# WELWYN HATFIELD COUNCIL

## PLANNING DECISION NOTICE – REFUSAL

S6/2003/1311/FP

ERECTION OF TWO STOREY SIDE EXTENSION AND REAR CONSERVATORY

FOR FRESHOLDERS: MRAUS ADKIN  
 MR & MRS J AND M ADKIN, WYNDHAM COTTAGE, CAMFIELD PLACE, ESSENDON HEATHS AL9 6SE  
 PROPOSED GABLED GROUND FLOOR EXTENSION + GROUND FLOOR CONSERVATORY  
 DRAWING NO. 1 PLAN ELEVATIONS. RED MARKS PROPOSE AREA. AUGUST 03  
 SCALE APP 2cm to 1 metre 1:50

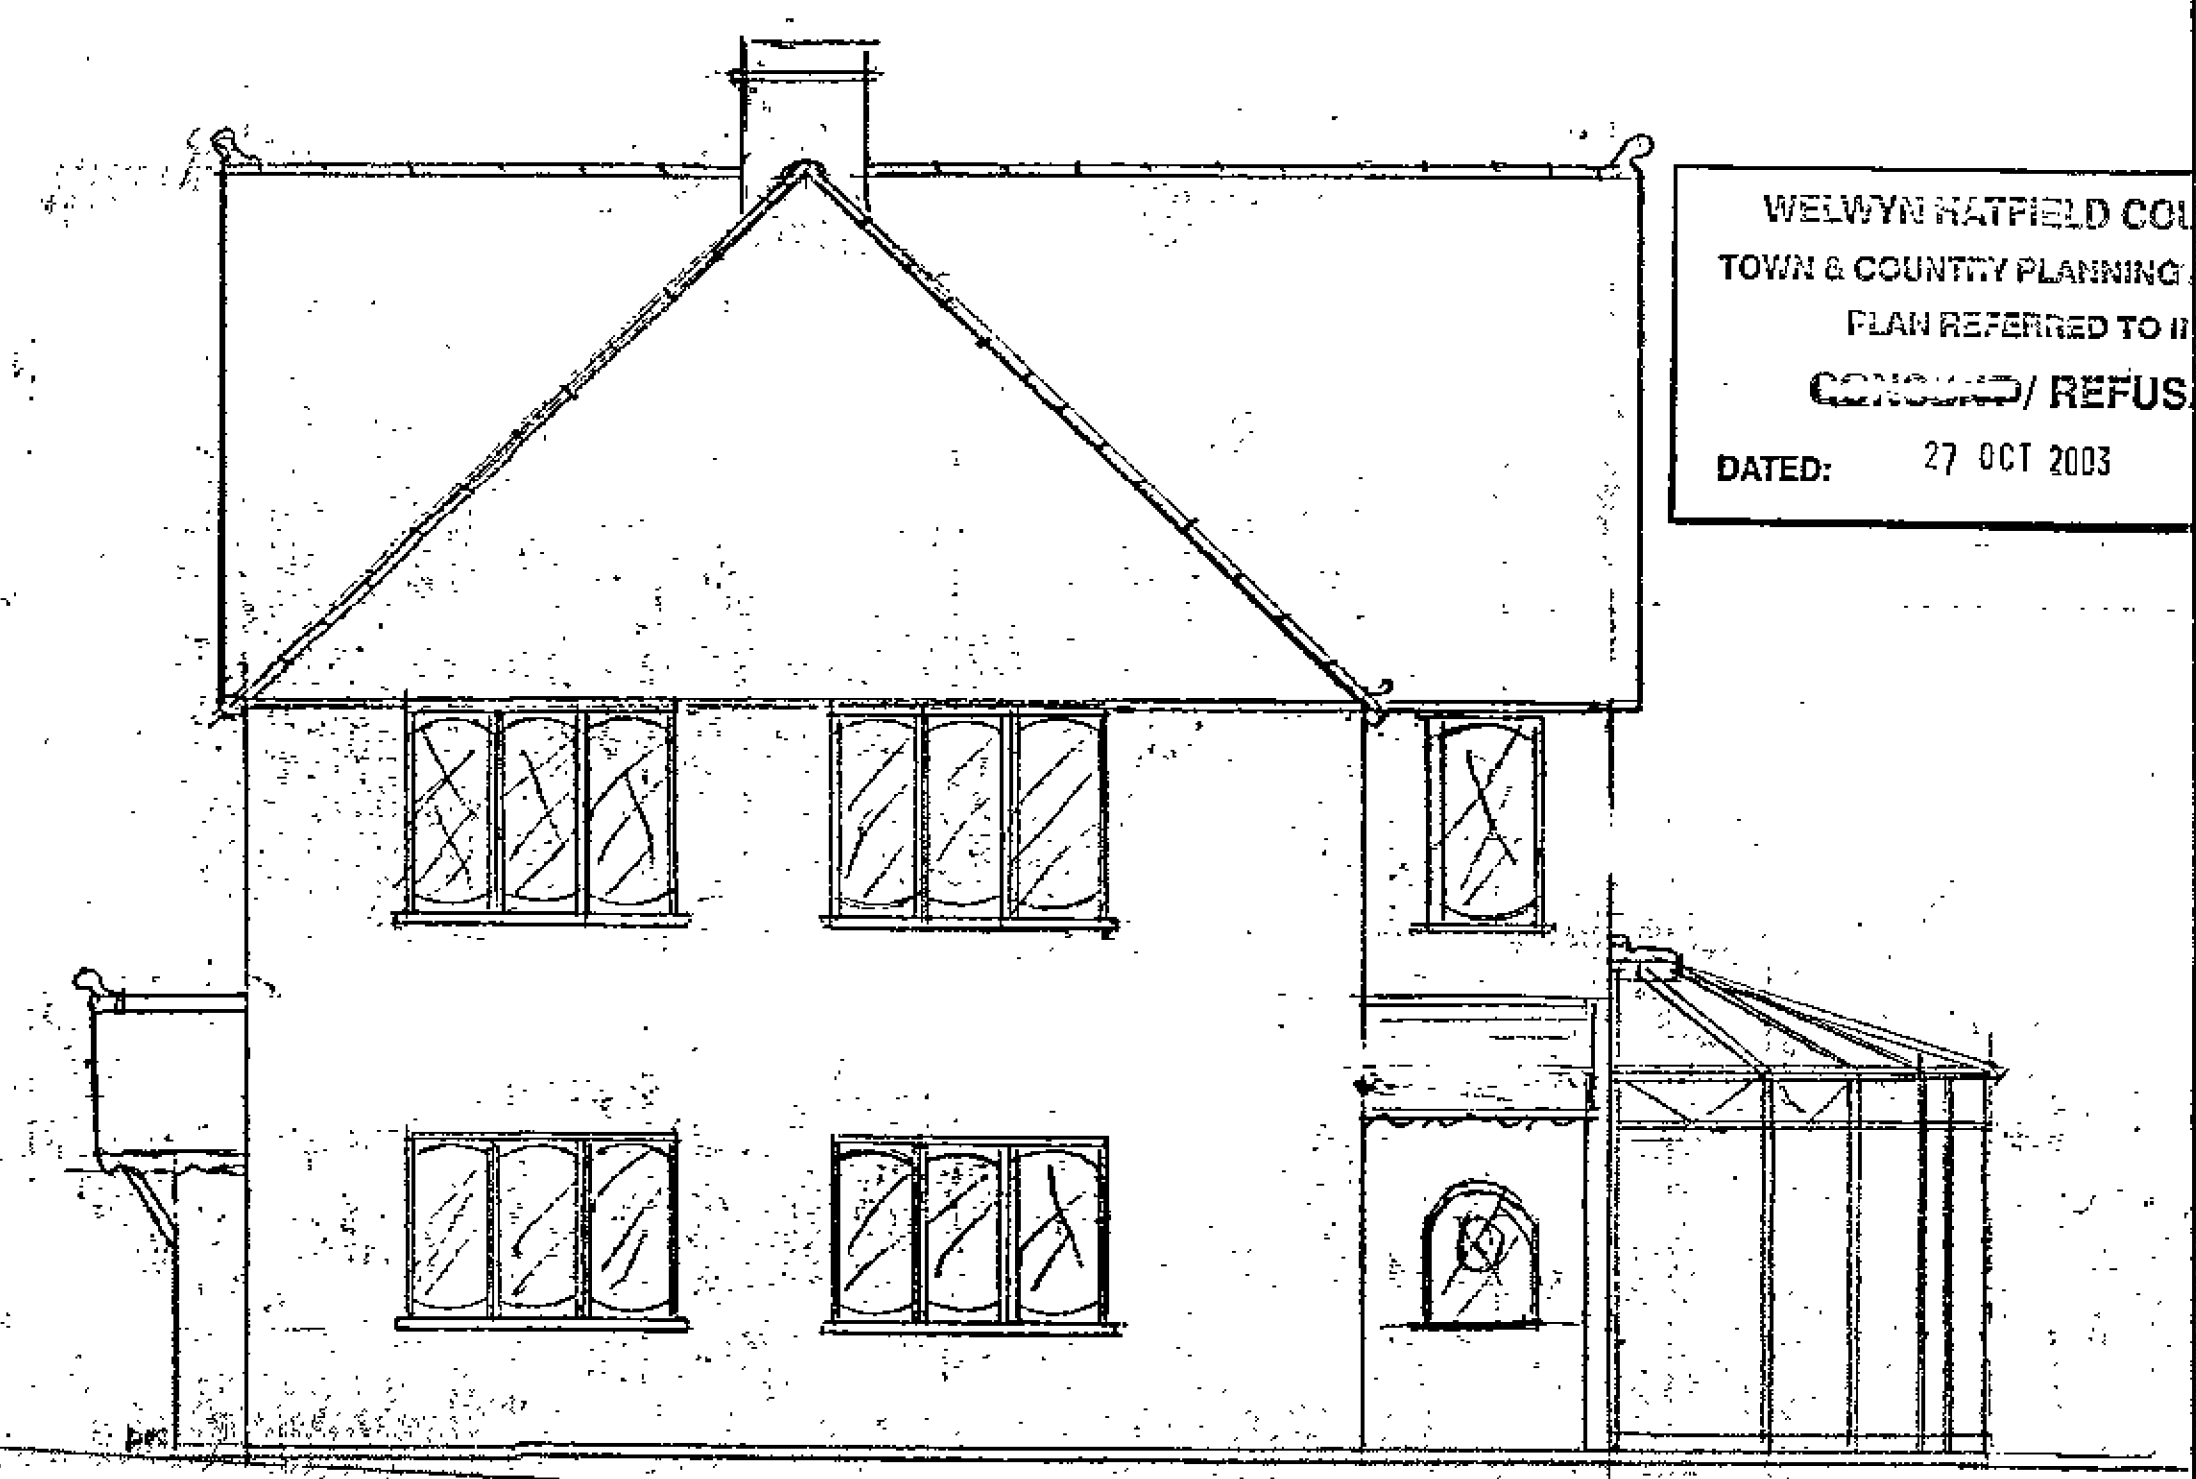
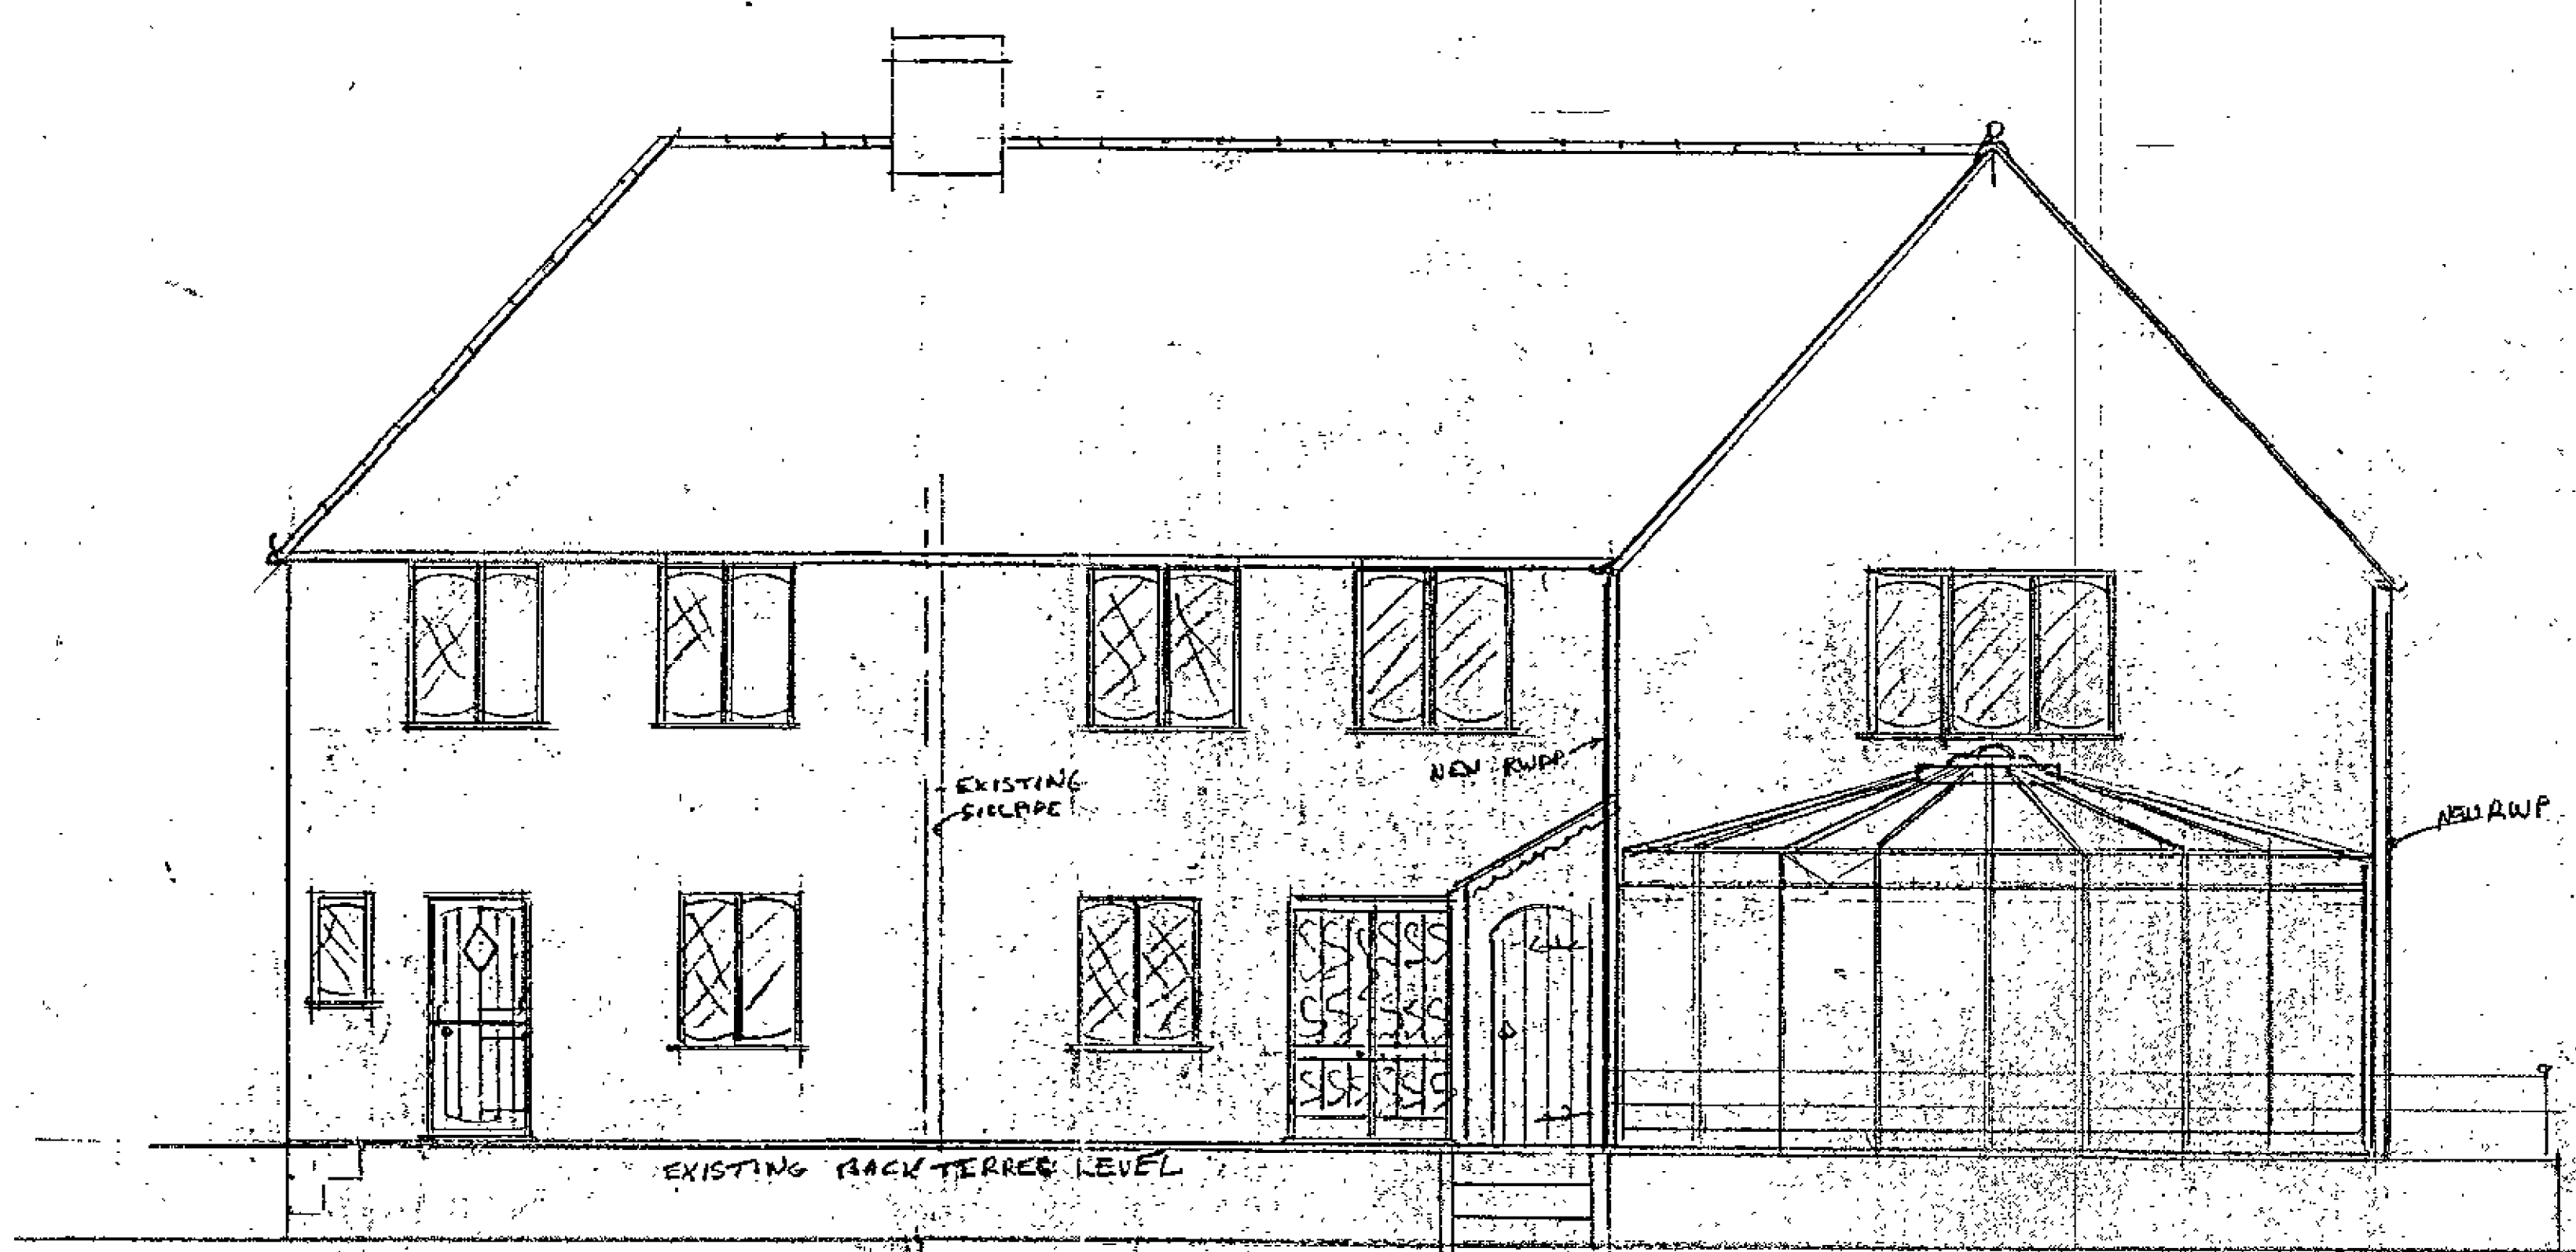
1. The proposed extensions will result in a disproportionate increase in the size and bulk of the original dwelling and as such will harm the openness of the Green Belt contrary to Policies GB3 and GB5 of the Welwyn Hatfield District Plan Alterations No.1, 1998 and Policies RA1 and RA3 of the Welwyn Hatfield District Plan Review, Revised Deposit Version, Published June 2002
2. The proposed extensions are not subordinate to the original house and do not reflect the design or character of the original dwelling and as such will harm the appearance of the dwelling contrary to the requirements of Policy Res Criteria 22 of the Welwyn Hatfield District Plan Alterations No.1, 1998 and Supplementary Design Guidance, Welwyn Hatfield District Plan Review, Revised Deposit Version June 2002
